Legalization Inspection – Code Enforcement

120 Allen Ave

**Building Sketch (Page - 1)**

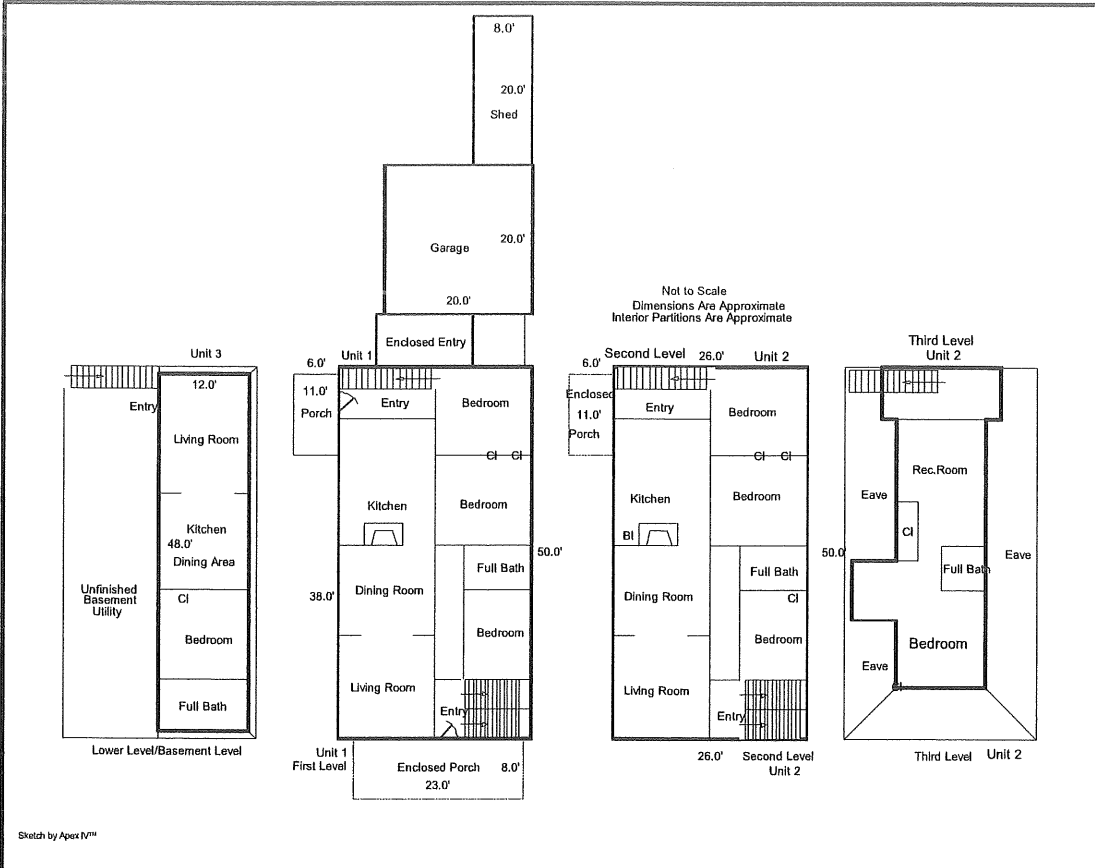
Basement:

Rough floor area measurements (Includes closets) $45' \times 12' = 540$ sq ft. Rough window area measurements 3 @ $34" \times 19" = 13.5$ sq ft (45 sq ft minimum openable area required)

Rough ceiling height measurement is 80" generally, however there is a beam in the middle of the main room that is 71" above the floor. (84" minimum required)
